**SSD 9403 – 1-2 MURRAY  
ROSE AVENUE, SYDNEY  
OLYMPIC PARK**

**RESPONSE TO SUBMISSIONS**

This 'Response to Submissions' Report (RtS) addresses the matters raised by stakeholders during public exhibition of the Environmental Impact Statement (EIS) for the residential development at No 1 and No 2 Murray Rose Avenue, Sydney Olympic Park.

1 ELEVATION_S1_NORTH
1:400 @ A3

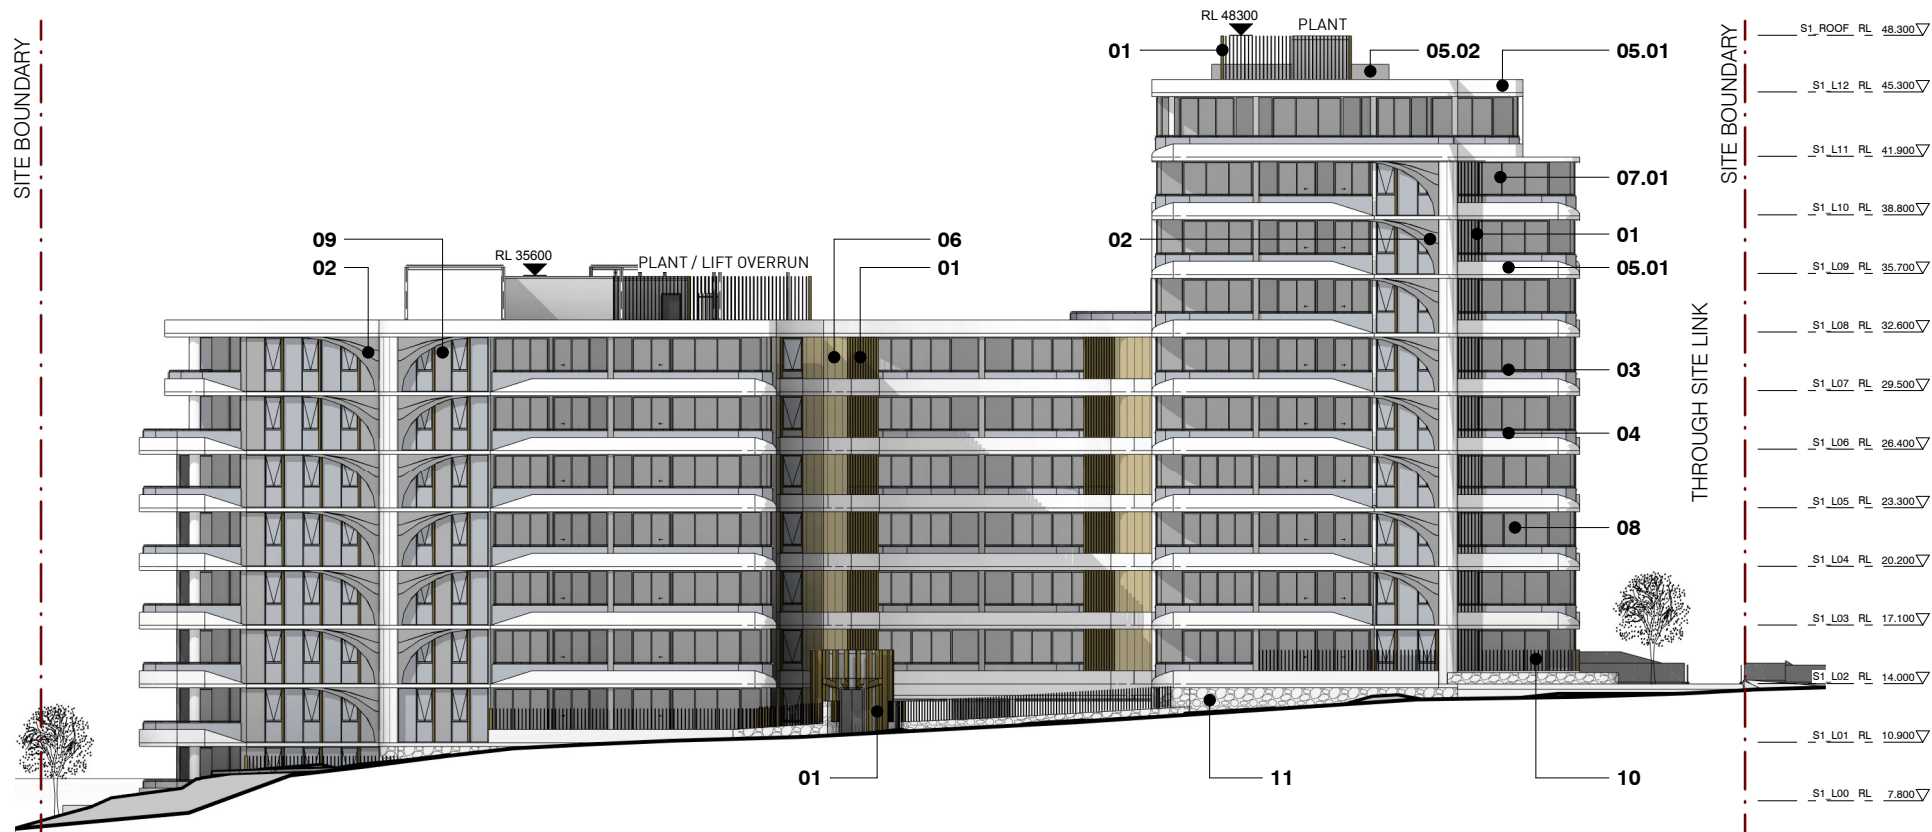
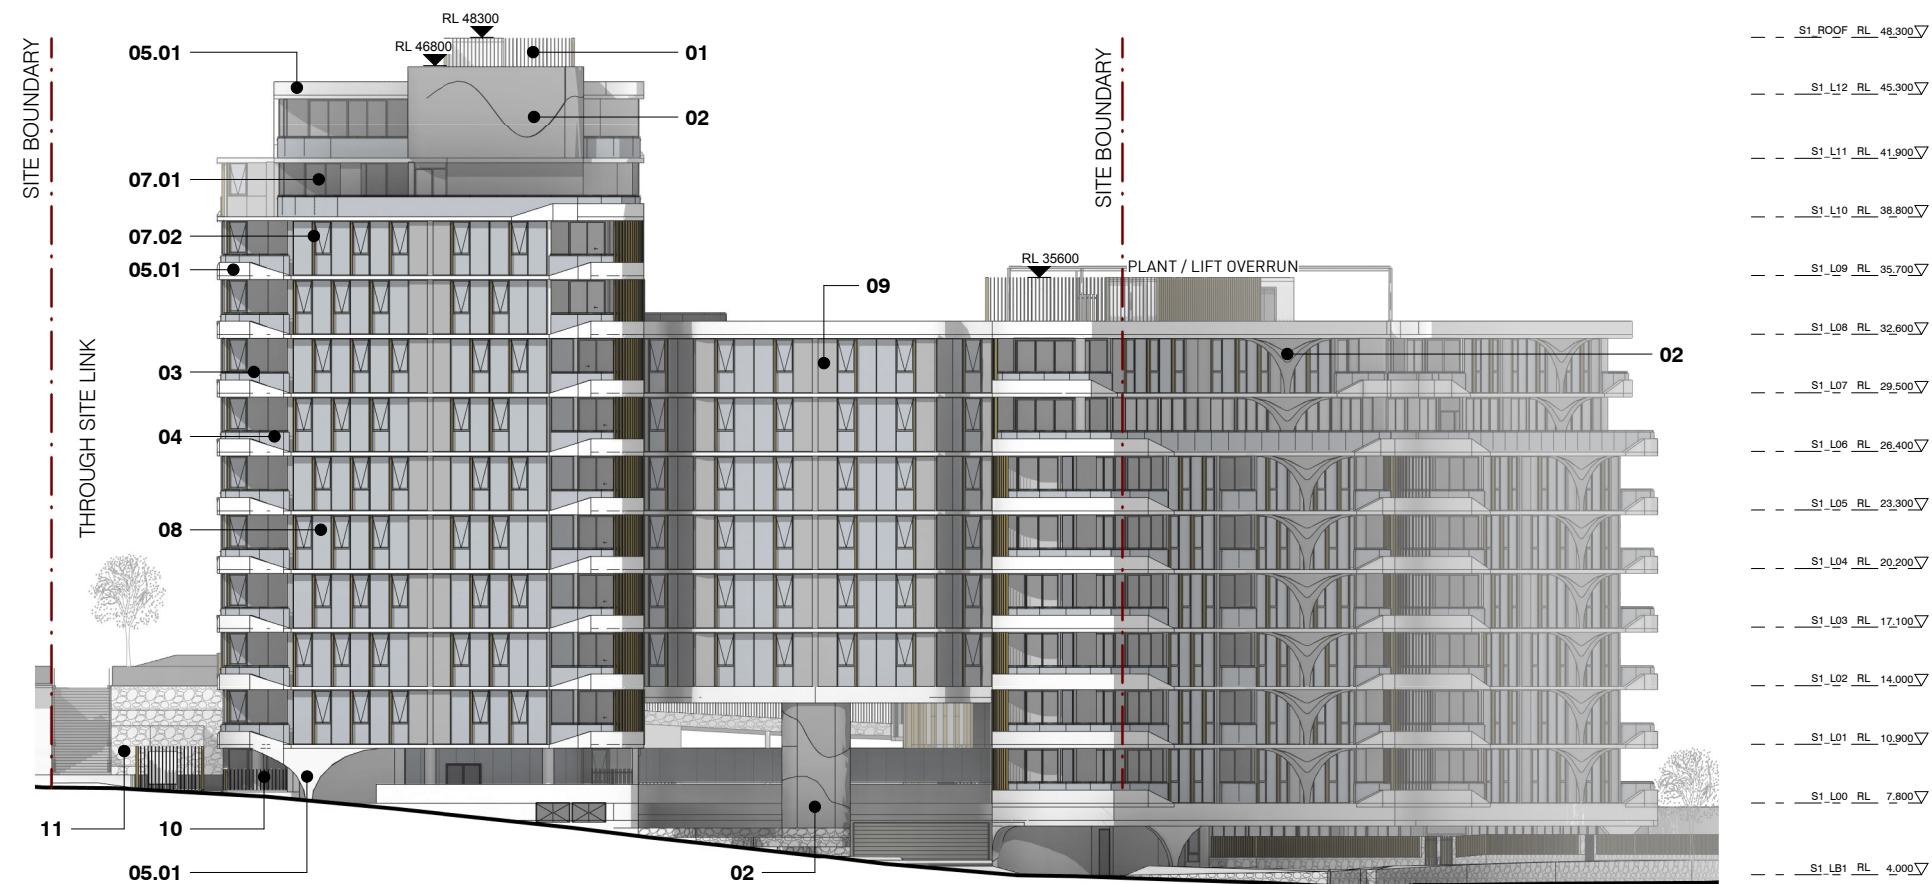
<b>NSW Police</b>			
17.	<p>NSW Police recommend that the following key matters are evaluated at the site:</p> <ul style="list-style-type: none"> <li>• Business Identification</li> <li>• Lighting</li> <li>• CCTV</li> <li>• Signage</li> <li>• Landscaping</li> <li>• Design Features</li> <li>• Fire Safety</li> <li>• Overcrowding and illegal renovations (for Council)</li> </ul>	<p>These matters have been address within section 7.6 of the EIS. These comments were also address during SEARS.</p> <p>Adequate and uniform lighting for entire property will be proposed in the design to comply with relevant standards.</p> <p>In terms of CCTV system the location of cameras will be provided by the architect and documentation of CCTV system will be provided.</p> <p>Adequate fire safety measures will be provided within the fire services design. Design will comply with all Australian Standards and BCA requirements.</p>	<p>Refer to the EIS submitted with the original application package.</p> <p>Refer Appendix A below.</p>

Issue	Comment	Response	Refer to
	<ul style="list-style-type: none"> <li>• Traffic concerns</li> <li>• Other issues – including inadequate alarms, illegal activity, drug trafficking, vandalism and access</li> </ul>	<p>Street numbers have been added to the north and south elevations in response to these comments.</p> <p>A Traffic Impact Assessment has been prepared and submitted with the SSDA. Traffic accident data was not included within this report, however, this information can be provided, if so required.</p>	
<b>Office of Environmental and Heritage (OEH Environment)</b>

1 ELEVATION_S1_WEST
1:400 @ A3

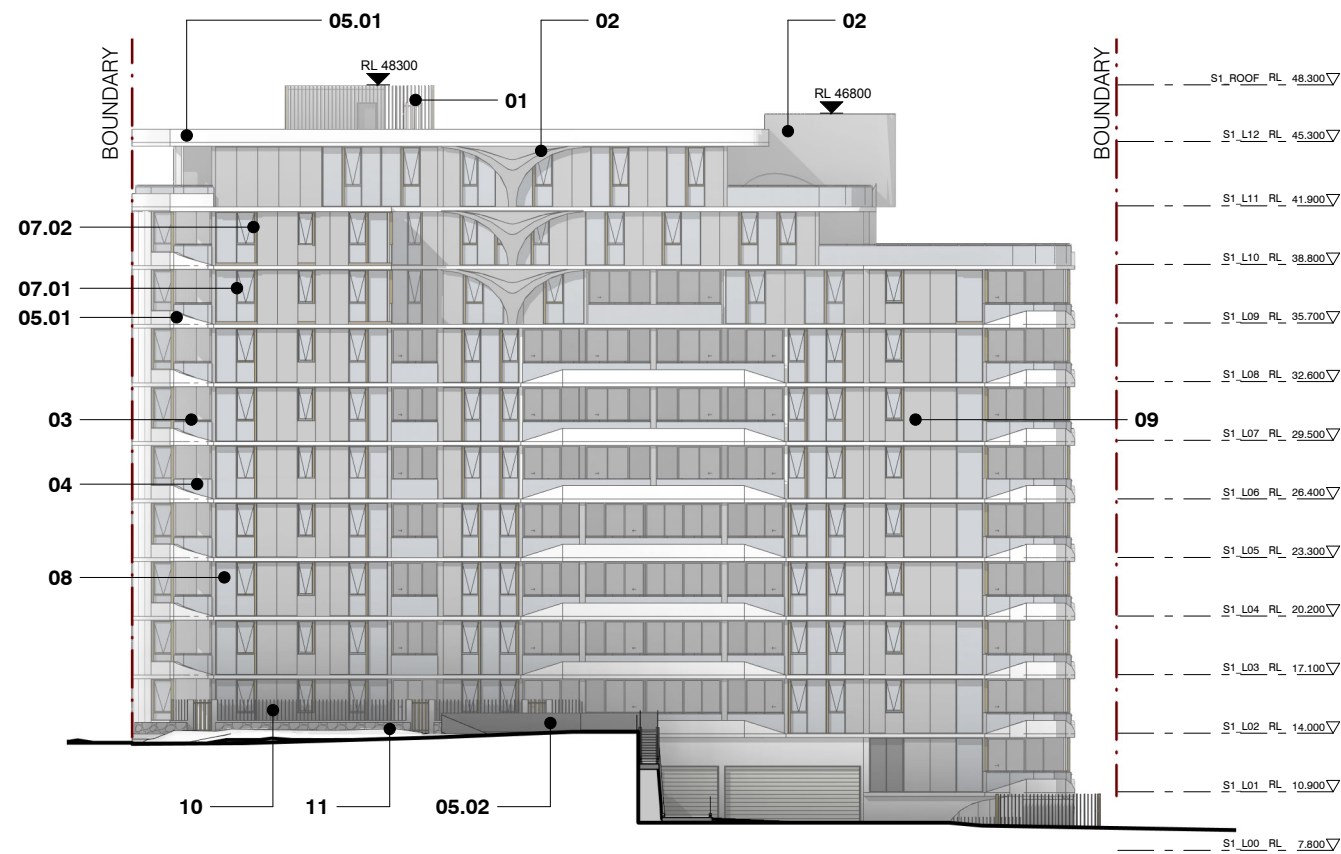
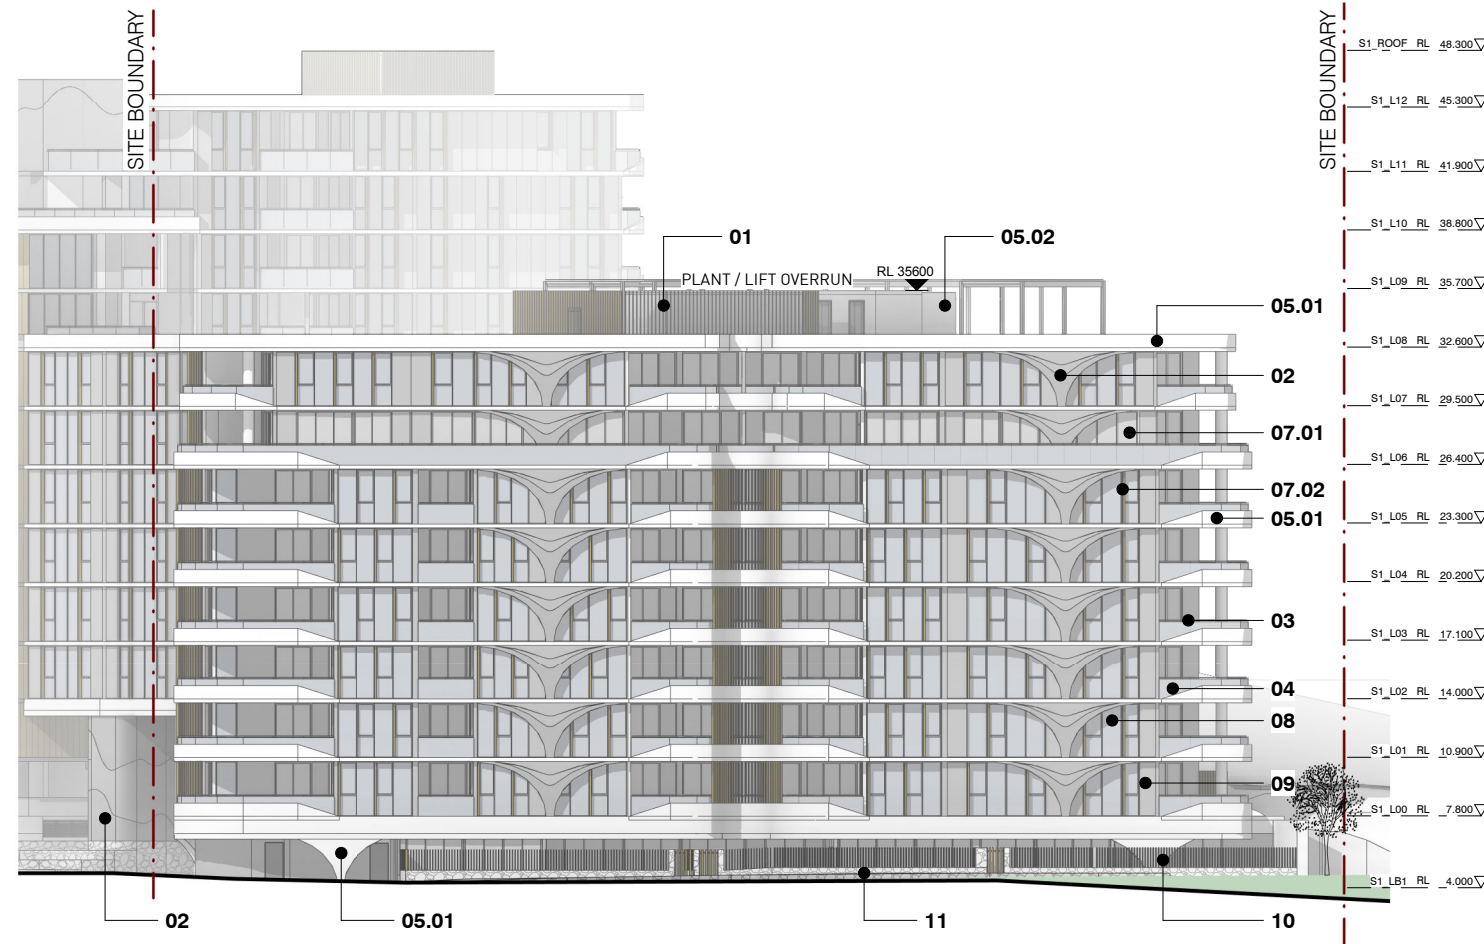
Issue	Comment	Response	Refer to
		<i>provide evidence of the pathway and scorecard to target 6 Star Green Star Design as Built Rating’.</i>	
3. Gross Floor Area	<p>The Wind Impact Assessment report identifies a need for 2.0m high impermeable screens to communal areas on Level 8 of Tower 2 and the large north and south-facing upper level balconies. If implemented, these screens result in the balconies and communal areas constituting additional gross floor area under the definition in the Standard Instrument.</p> <p>SOPA does not object in principle to the additional GFA that would be created by these screens but it should form part of the assessment of this application.</p>	<p>After careful consideration of the impact of wind on the amenity of residents as set out in the Windtec’s report the top floors of the development with large balconies have been redesigned to screen the wind throughout 2m high wind screen and in two units full height to the underside of balcony wind screen. Further consideration has also been given to including denser foliating vegetation to achieve suitable wind conditions. The numbering of the buildings has been included in the change to reflect other comments made.</p> <p>The revised plans are attached at Appendix A.</p>	Refer Appendix A.

- Balcony screening (16) and wintergardens (2) between levels 9-15 on site 1 and levels 8-15 on site 2 (affecting 18 units);
- One accessible visitor parking space on each site;
- Street numbers to be included on the south and North elevations of sites 1 and 2;
- An updated GFA schedule to outline the impact stemming from the above items; and
- Revised roof landscape layout.
